Appeal Decision

Appeal Ref: APP/R5510/W/15/3065776

22 Deane Avenue, South Ruislip, Middlesex HA4 6SR

- The appeal is made under section 78 of the Town and Country Planning Act 1990 against a refusal to grant planning permission.
 - The appeal is made by Crown Lodge Developments Ltd against the decision of the Council of the London Borough of Hillingdon.
 - The application Ref 70505/APP/2014/4406, dated 13 December 2014, was refused by notice dated 3 March 2015.
 - The development proposed is demolition of existing bungalow and replacement with a new build block of 4 no. 2 bedroom flats.
-

drg title
PROPOSED LAYOUTS

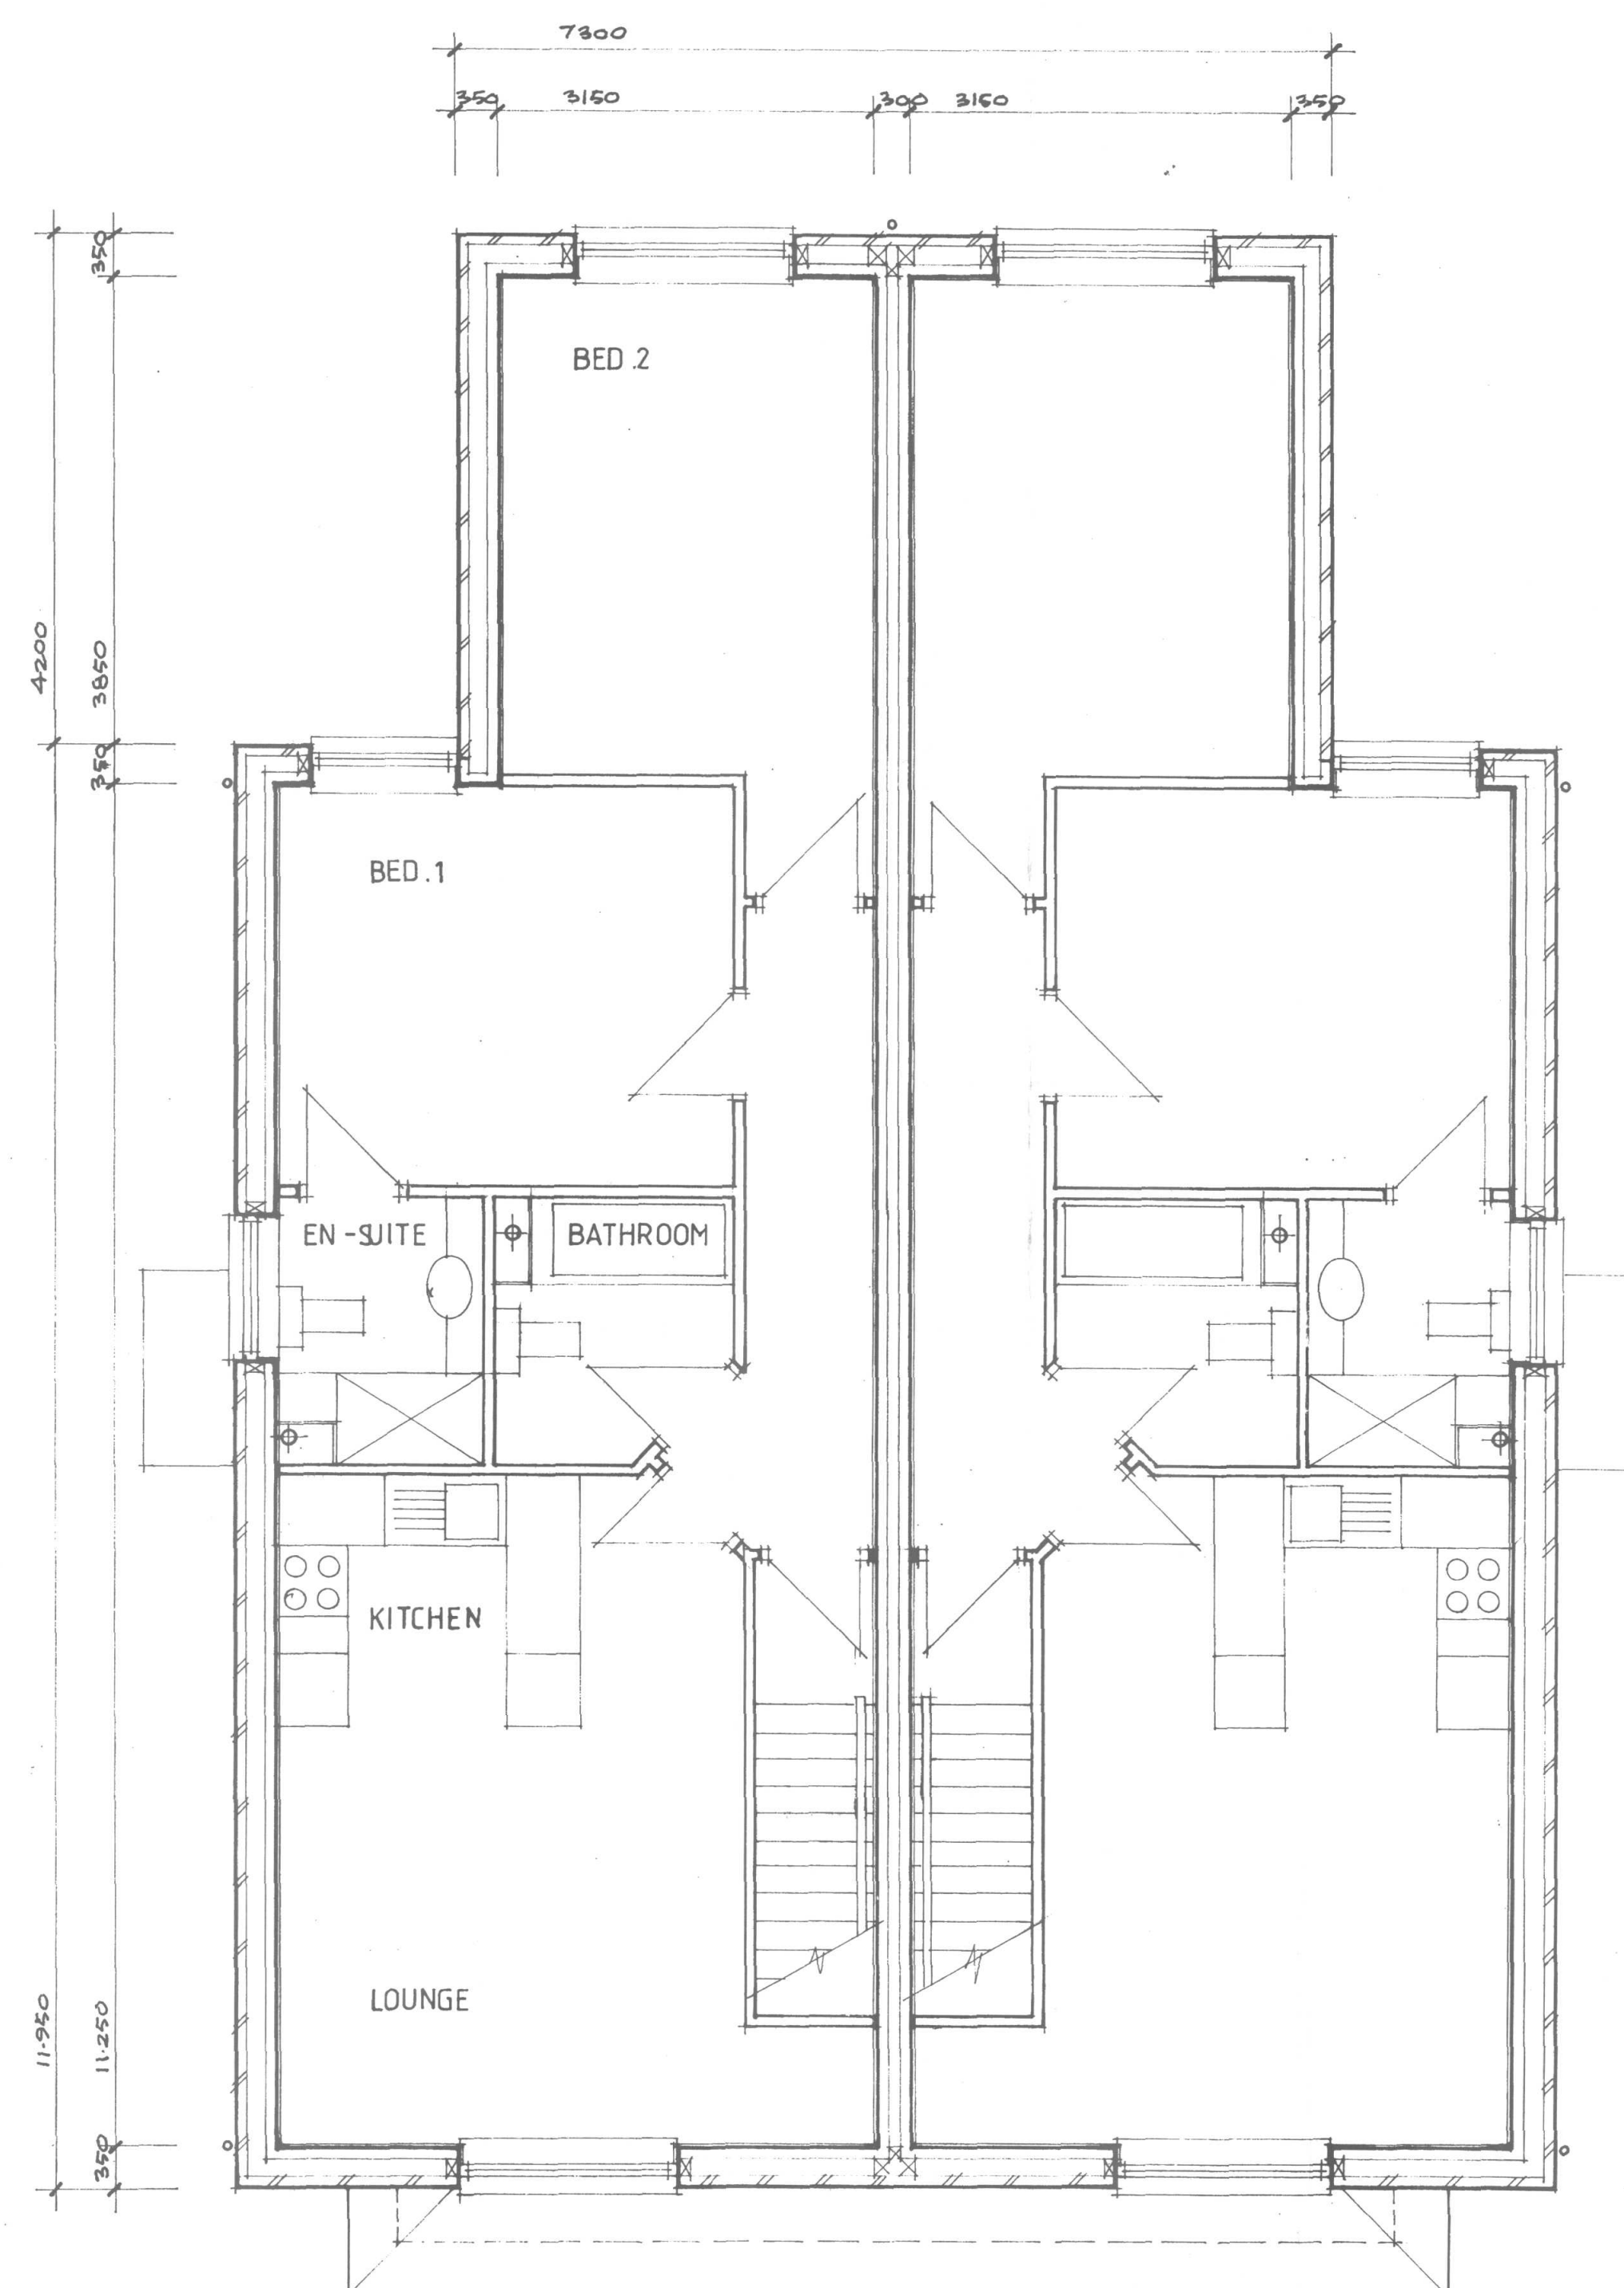
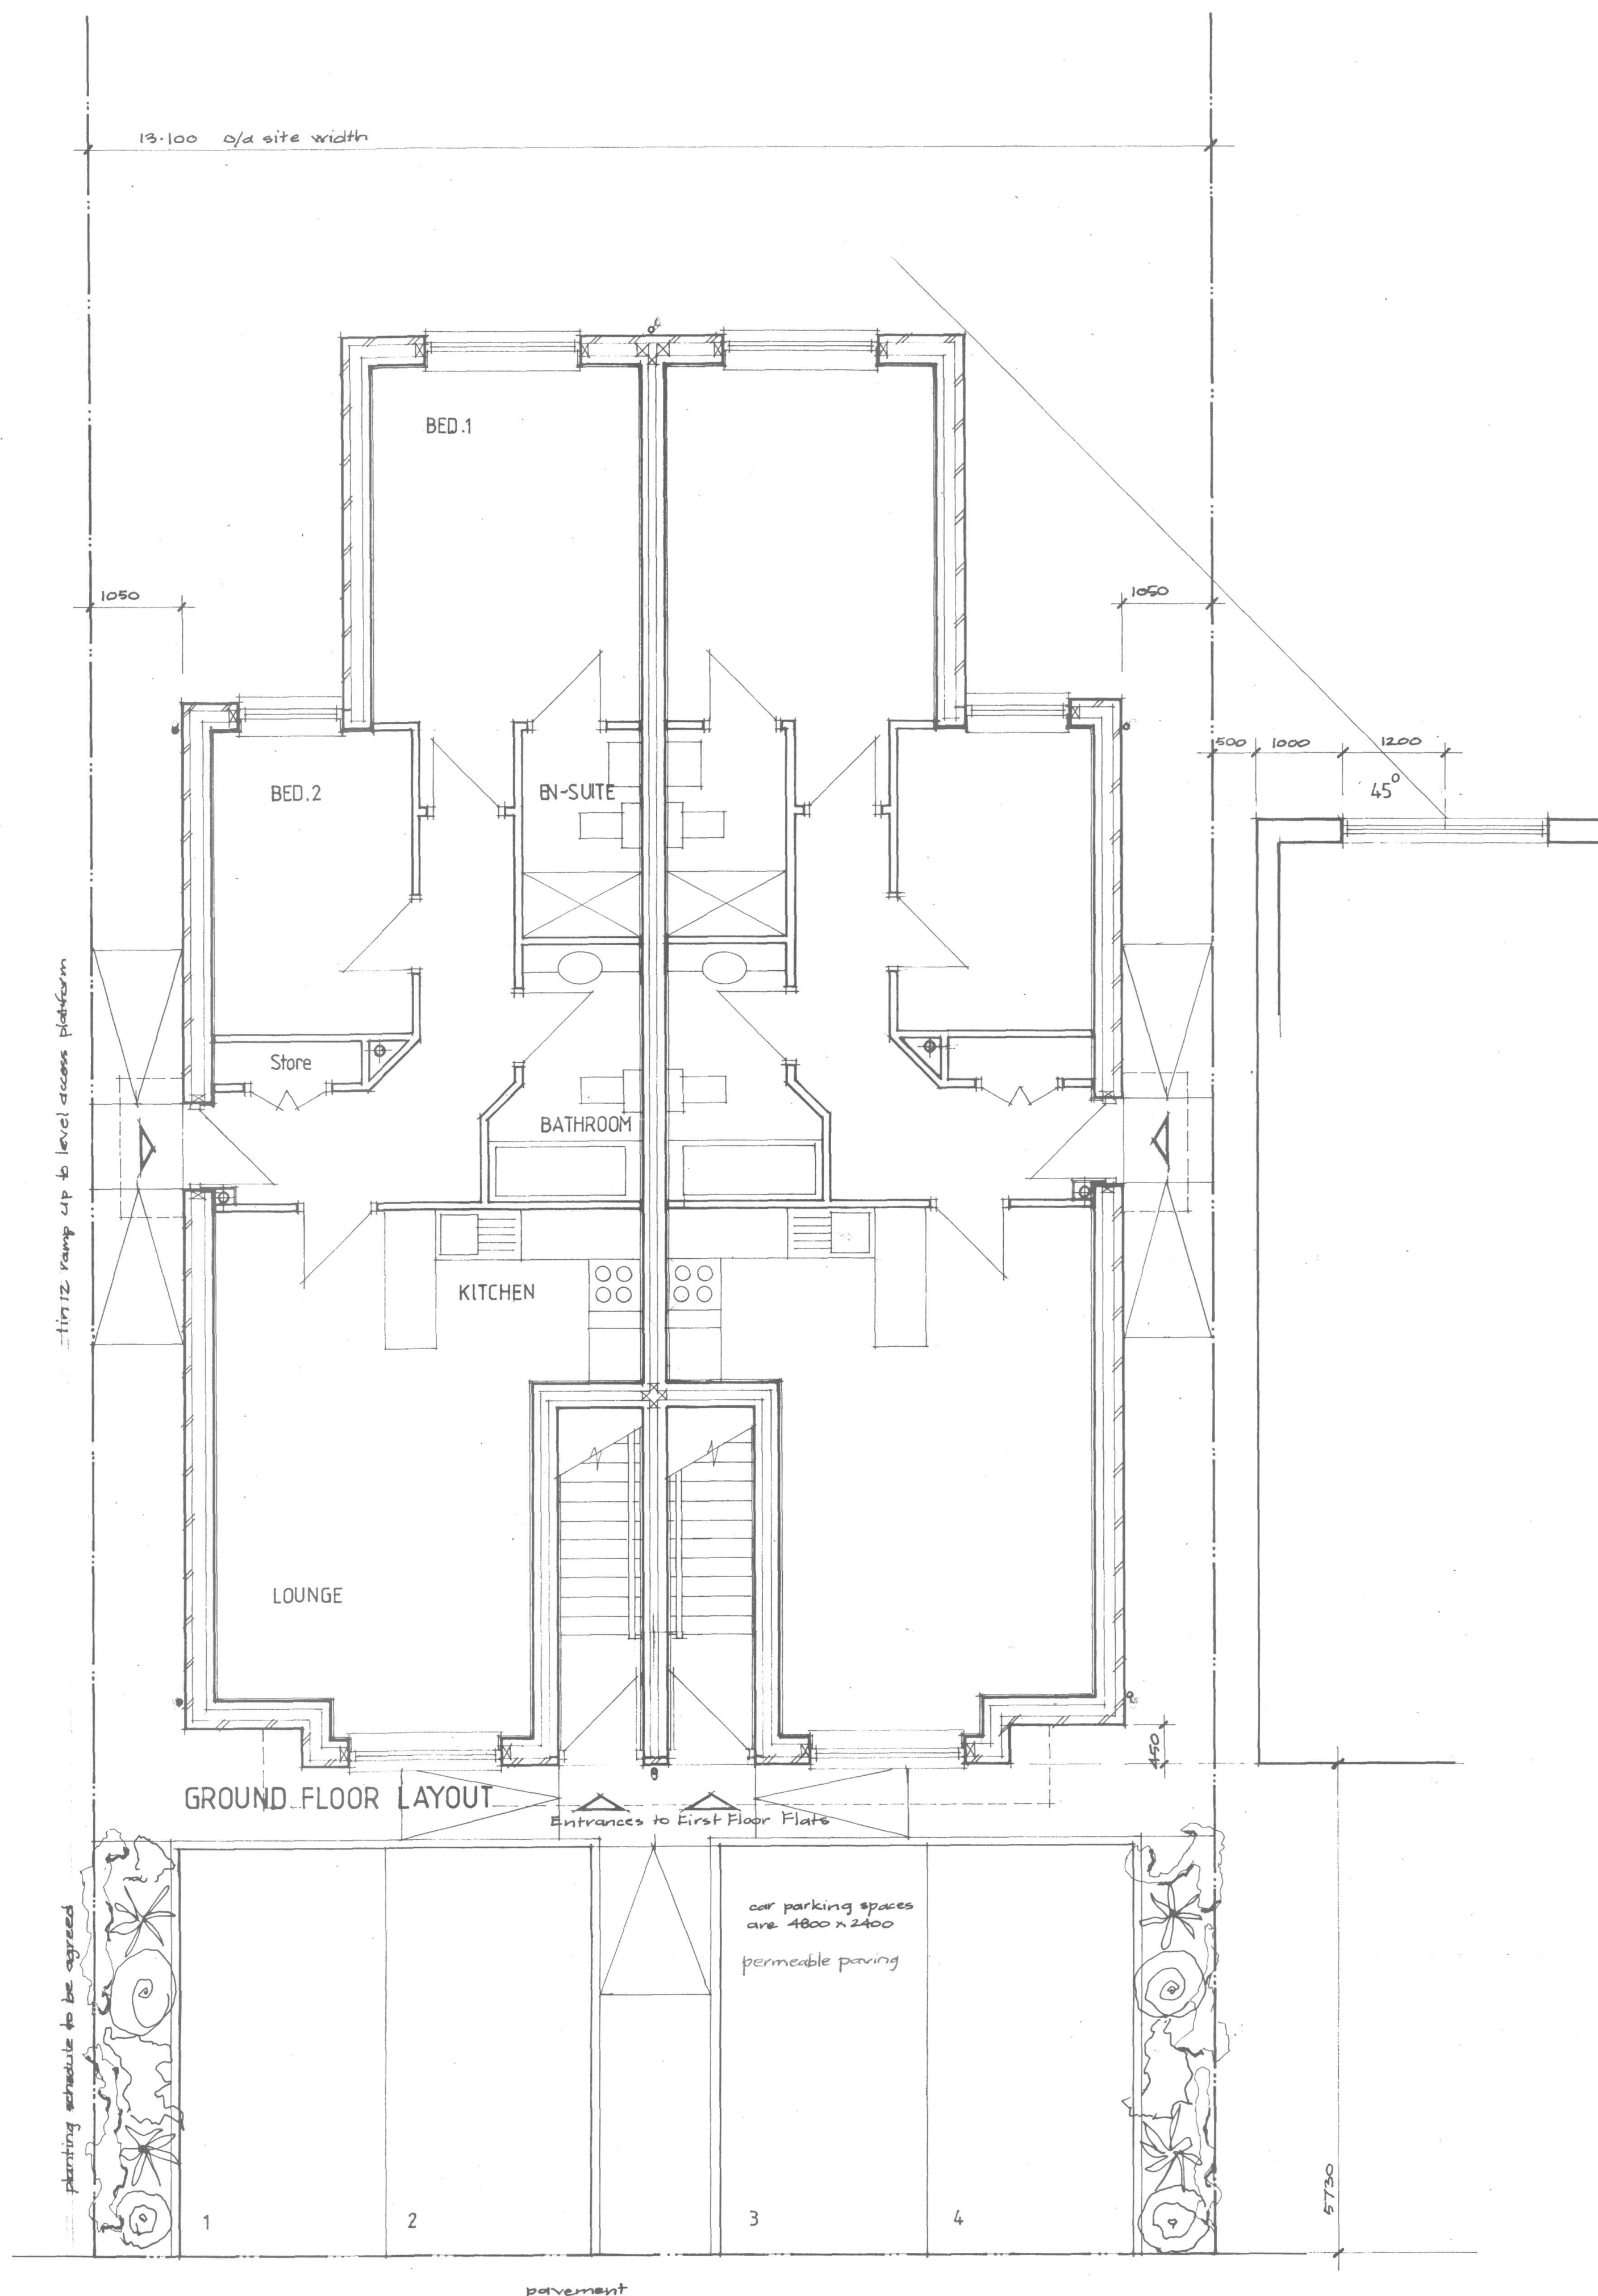
6. A shared cycle and bin store is proposed within the rear garden area which is to be used as a communal amenity space for the occupiers of the 4 flats. Given the location of the bedrooms to the ground floor flats these arrangements would give rise to a loss of privacy to the occupiers of those properties and some degree of noise and disturbance on a regular basis. I therefore conclude that the proposal would have adverse effects on the living conditions of the future occupiers of the ground floor accommodation and would conflict with Policies BE19, BE21 and BE24 of Part Two of the Hillingdon Local Plan which seek to ensure the privacy and amenity of residential occupiers.
